Application for a non-material amendment following a grant of planning permission.

Number	87
Suffix	
Property name	
Address line 1	Golden Avenue
Address line 2	
Address line 3	
Town/city	East Preston
Postcode	BN16 1QT
Description of site location must be completed if postcode is not known:	
Easting (x)	507744
Northing (y)	101865
Description

Two storey rear extension

K/26/18/HH

DRAWING TITLE: PROPOSED EXTENSION  
 TITLE: 87 GOLDEN AVENUE  
 EAST PRESTON  
 SCALE: 1:50  
 DATE: FEBRUARY 2018 REV2 FEB 2019  
 DRG NO: SW SHEET 2 OF 5  
 NOTE: THIS DRAWING IS TO BE  
 READ IN CONJUNCTION WITH  
 APPENDIX A

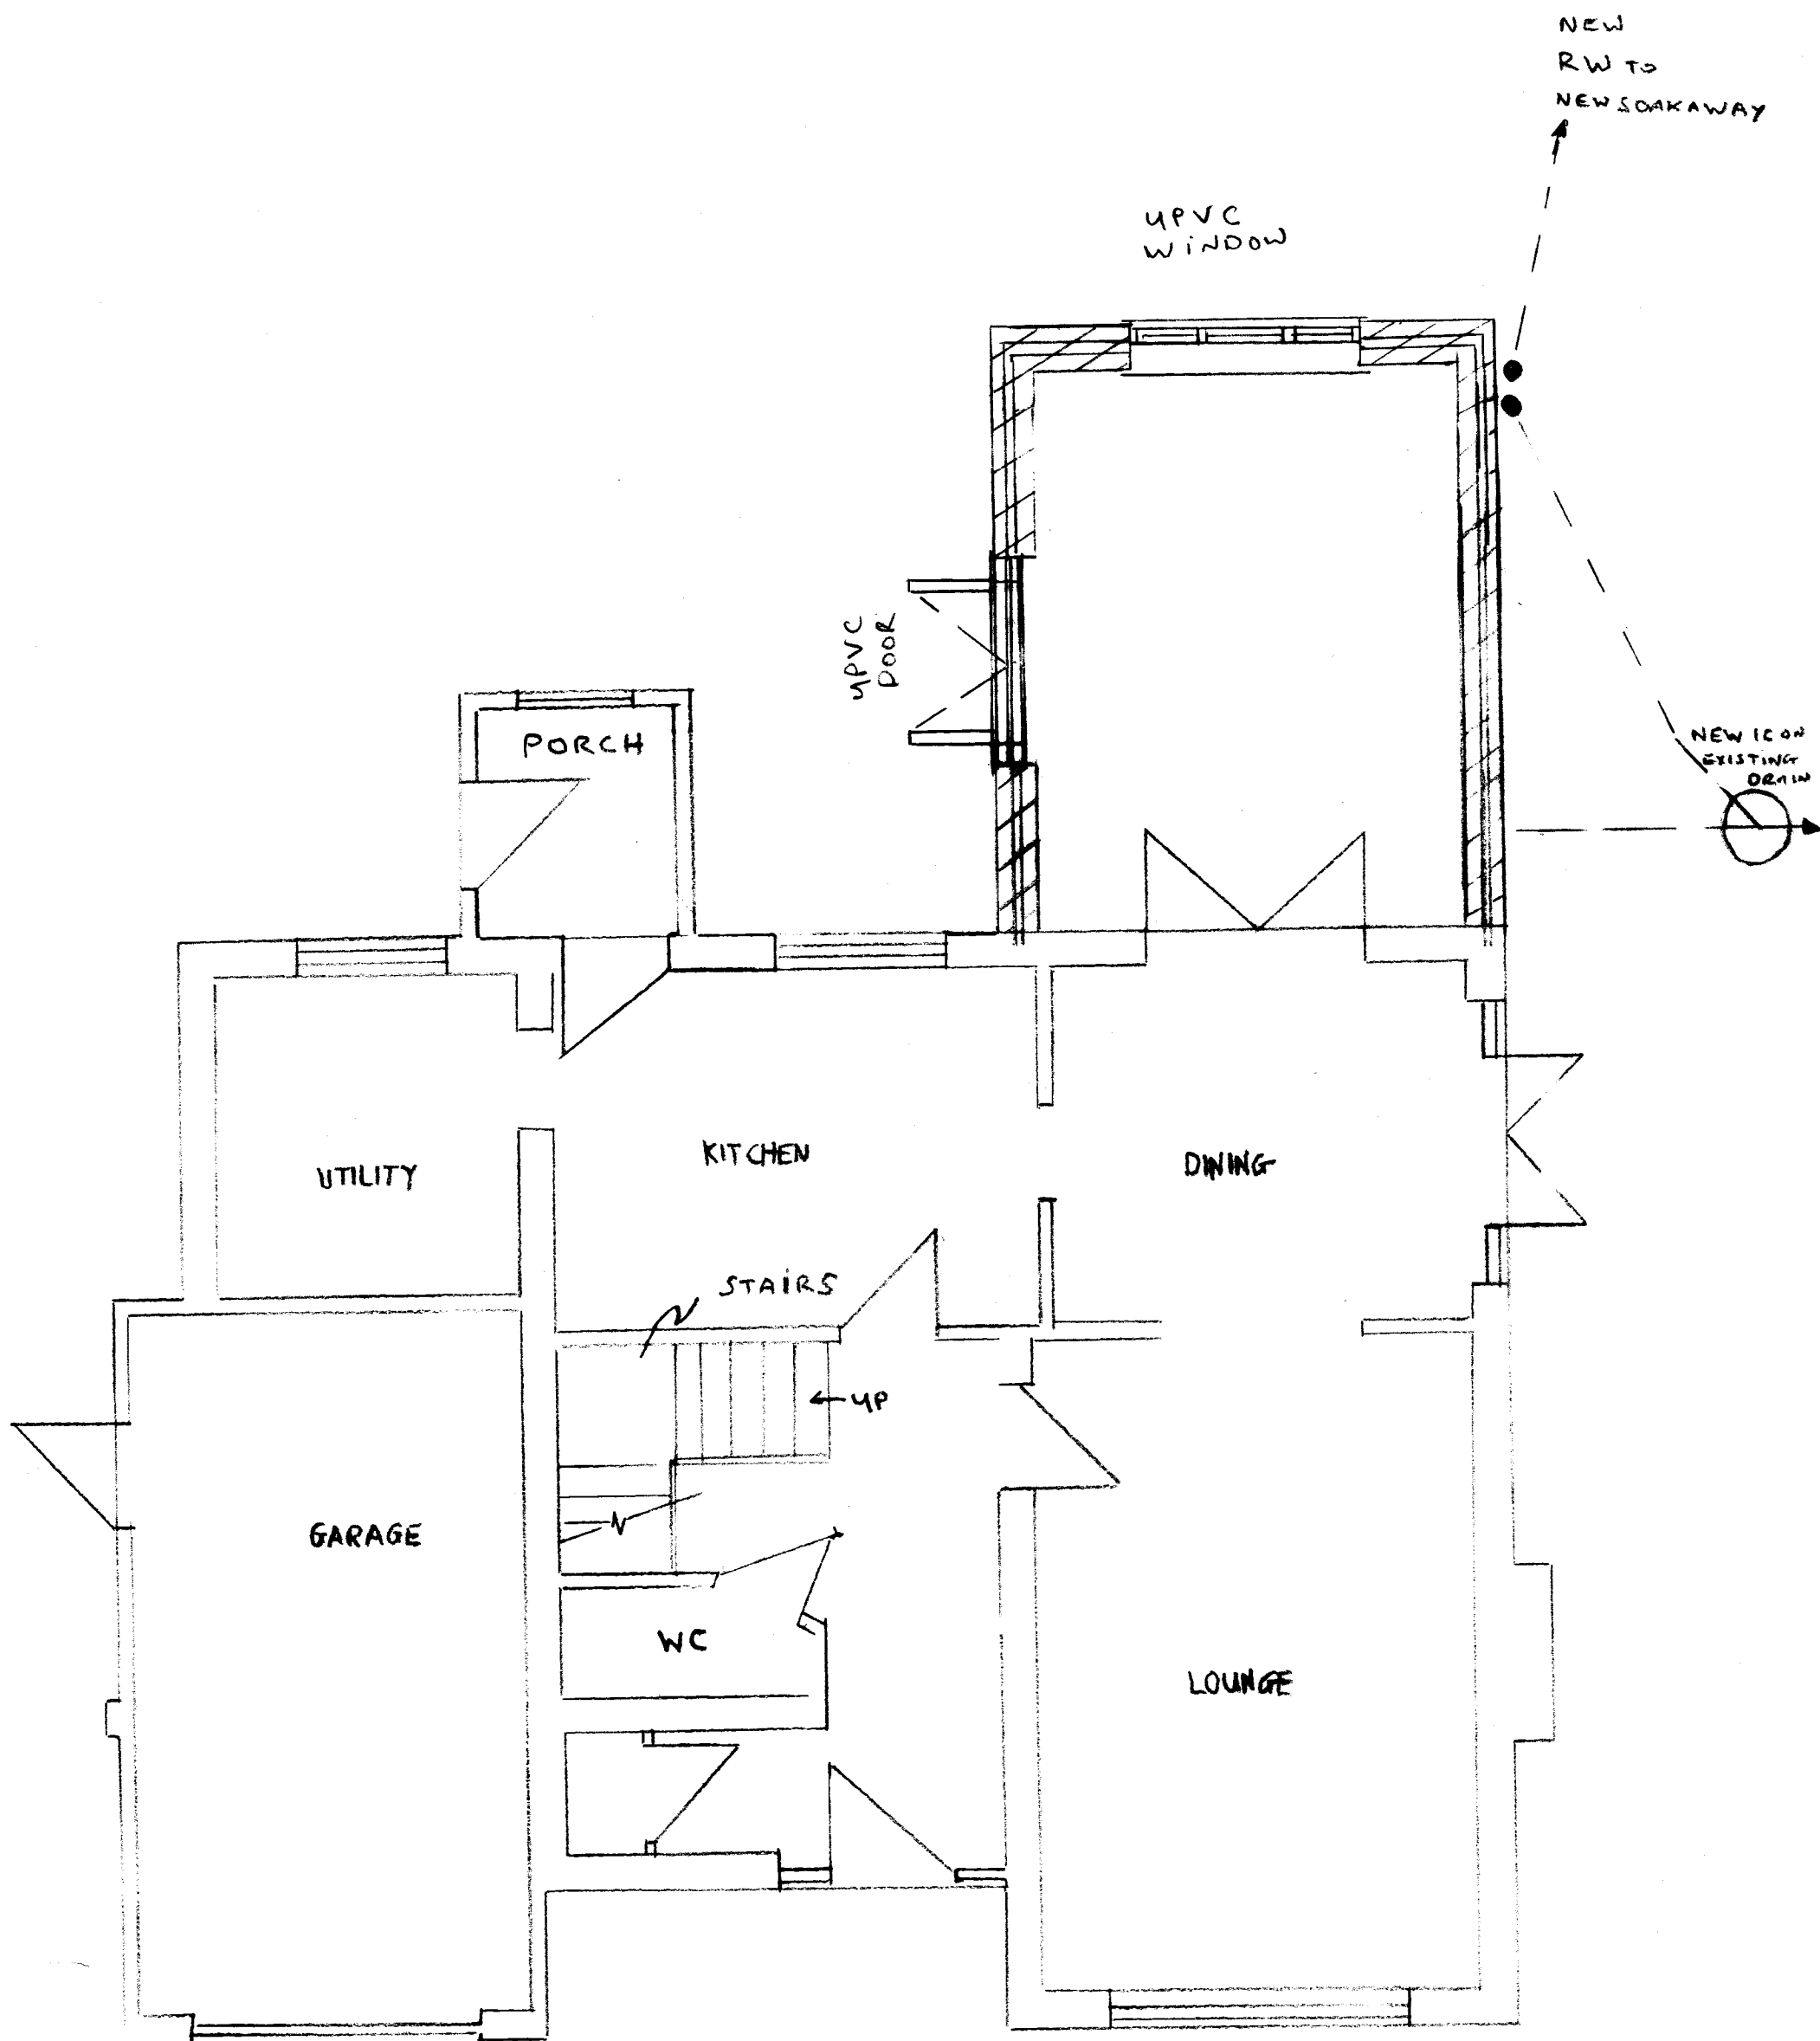
1) Increase length of two storey extension by 0.5 meters. 2) Reposition UPVC door on ground floor side elevation (N) to make more central. 3) Orientation of bathroom on suite changed at 90 degrees. 4) 1 window with obscure glass centrally positioned in bathroom on suite rear elevation and 1 window with obscure glass positioned on side elevation (N) . 5) 1 window in bedroom extension positioned on side elevation (N).
